File No: NTH07/01145; CR2015/000561
Your Ref: SSD 6848

SSD 6848 – Lismore Base Hospital Redevelopment and New Car Park Stage 3B

Roads and Maritime has undertaken a peer review of the "*Lismore Hospital Stage 3B Works and Multi-Storey Car Park Traffic and Parking Report*" and considered the capacity of the existing state road network to manage the proposed traffic flows. Generally it was found that the impact on the state road network is expected to be minimal.

SERVICE YARD - TRUCK DRIVE IN

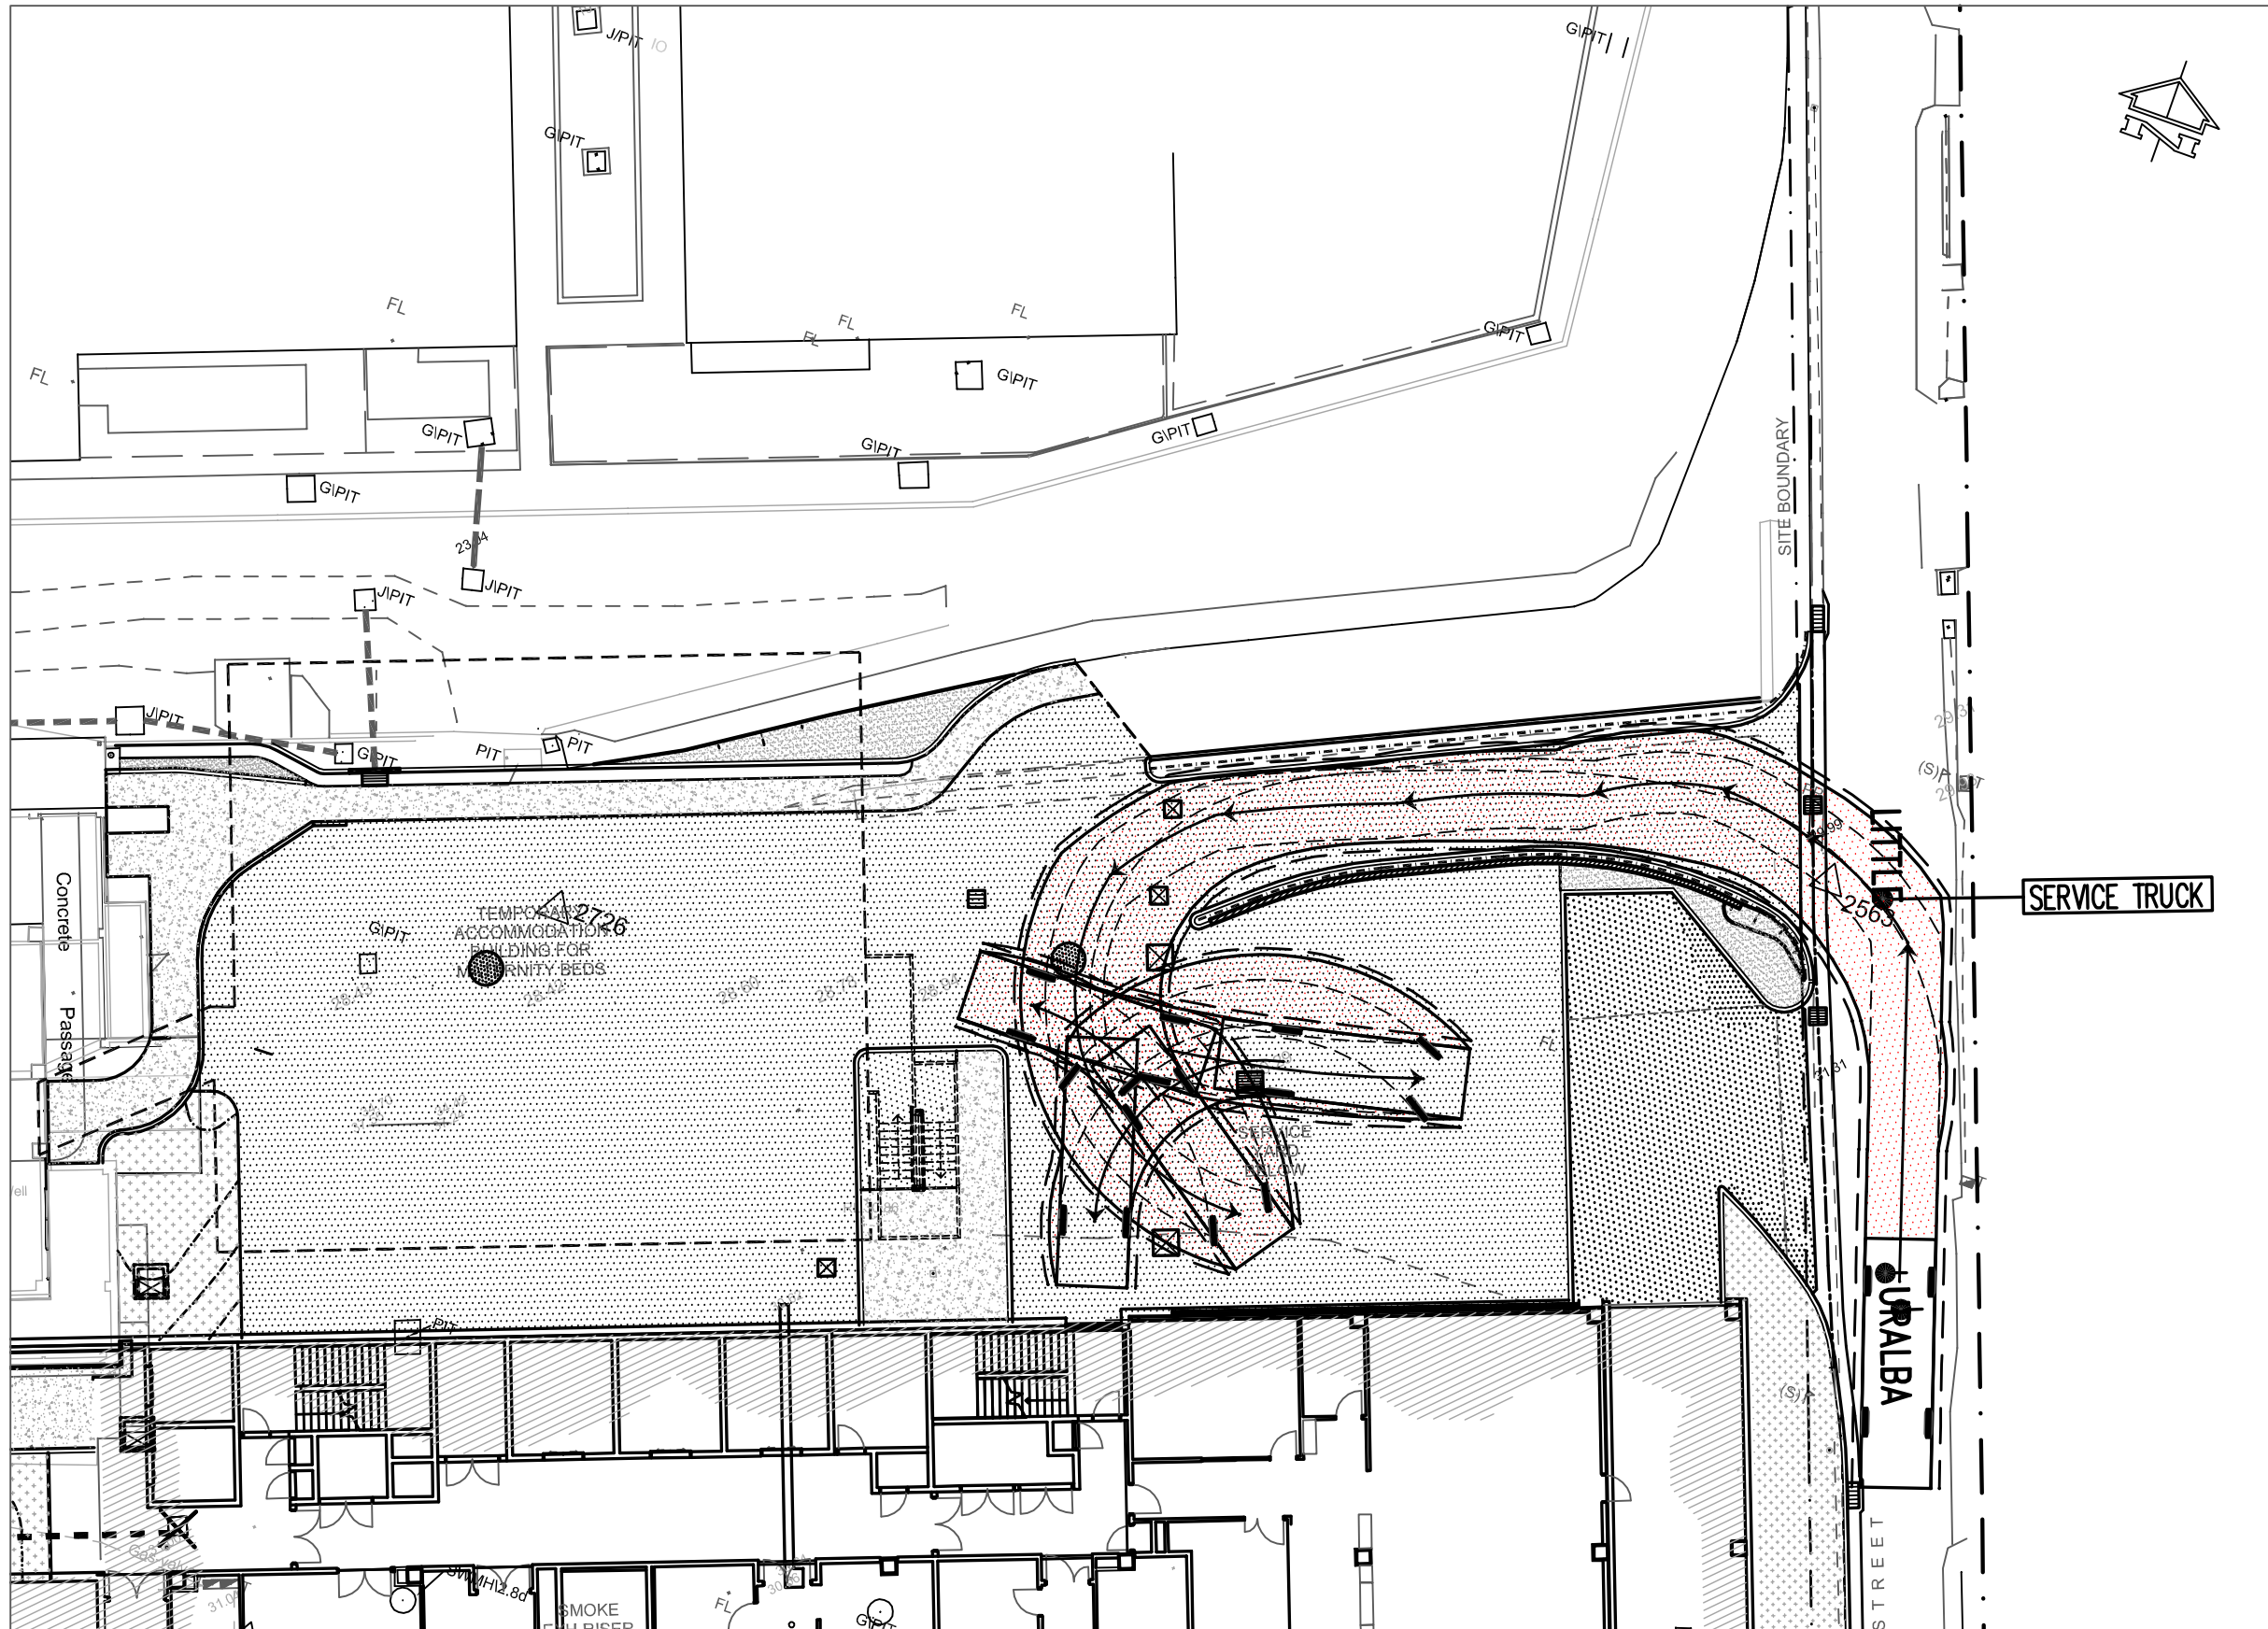
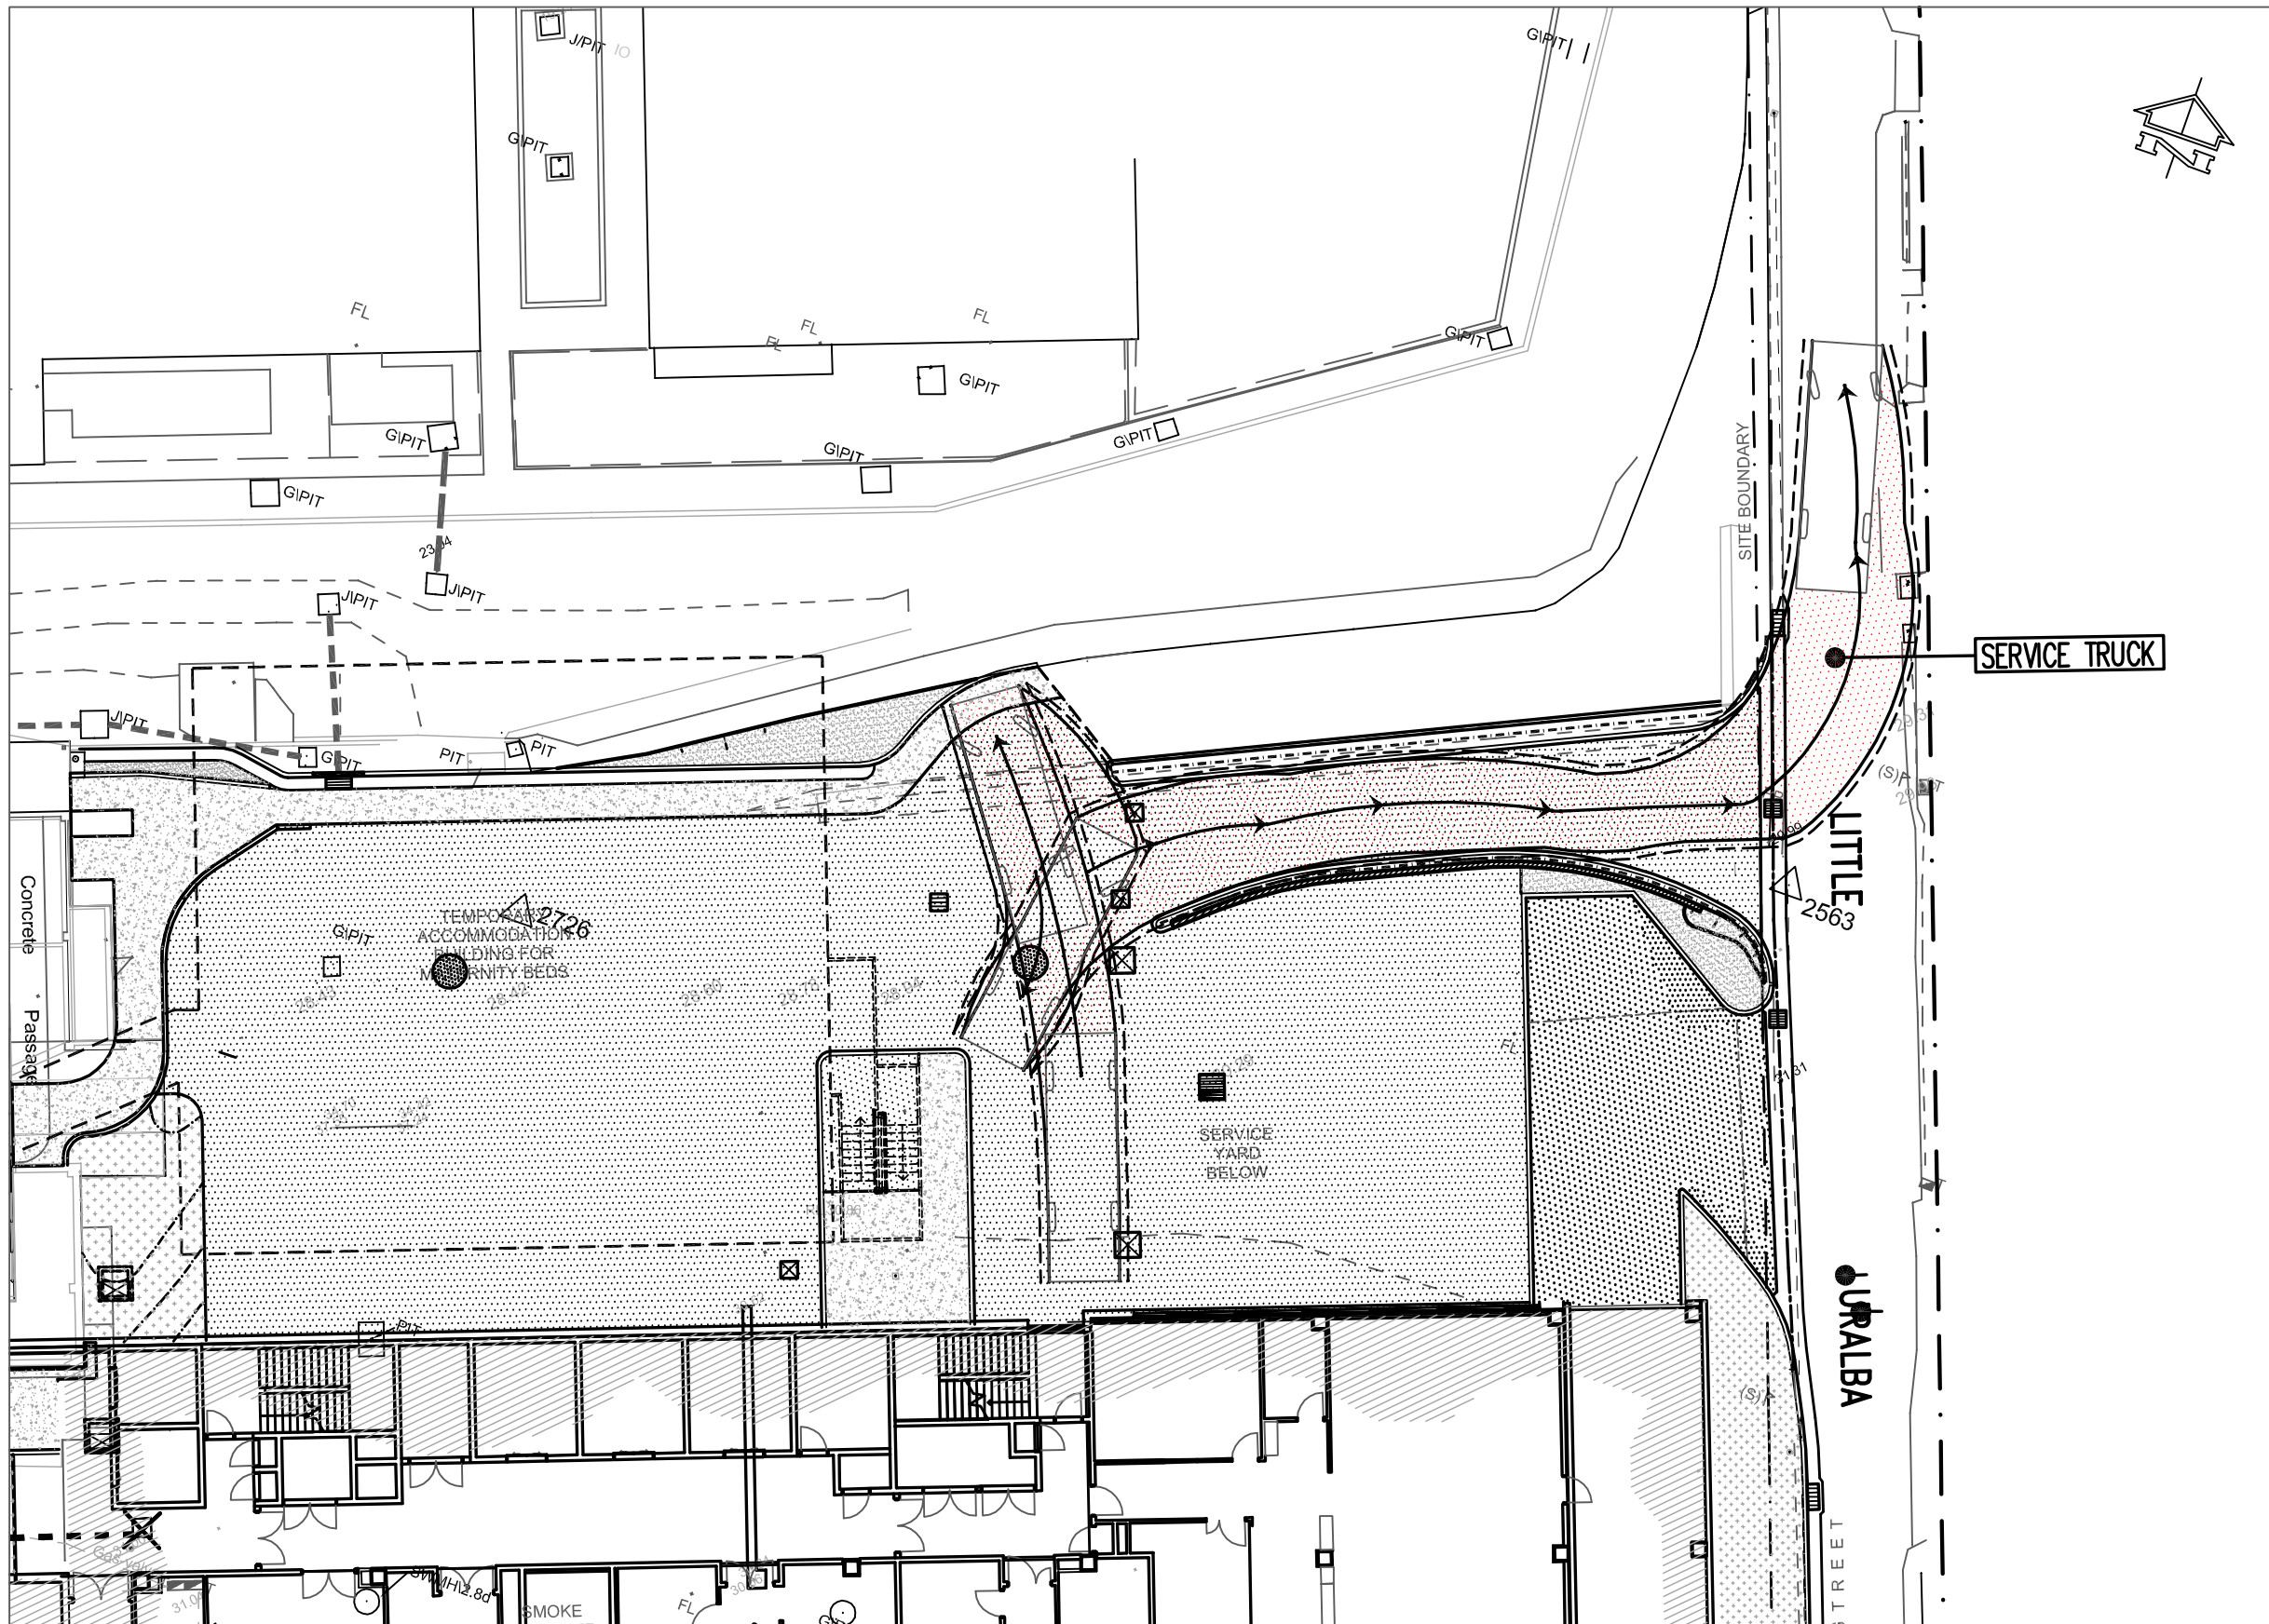
3. All service vehicles should be required to enter and leave the servicing area in Little Uralba Street in a forward manner. Reversing along or across a public road is not supported. It may be appropriate to consider implementation of a Traffic Management Plan to manage this activity.
4. In accordance with the Delegation to Councils for the Regulation of Traffic the installation of any regulatory devices on local roads or within road related areas, including marked pedestrian crossings and parking signs, require the endorsement of the Local Traffic Committee (LTC) prior to Council approval.
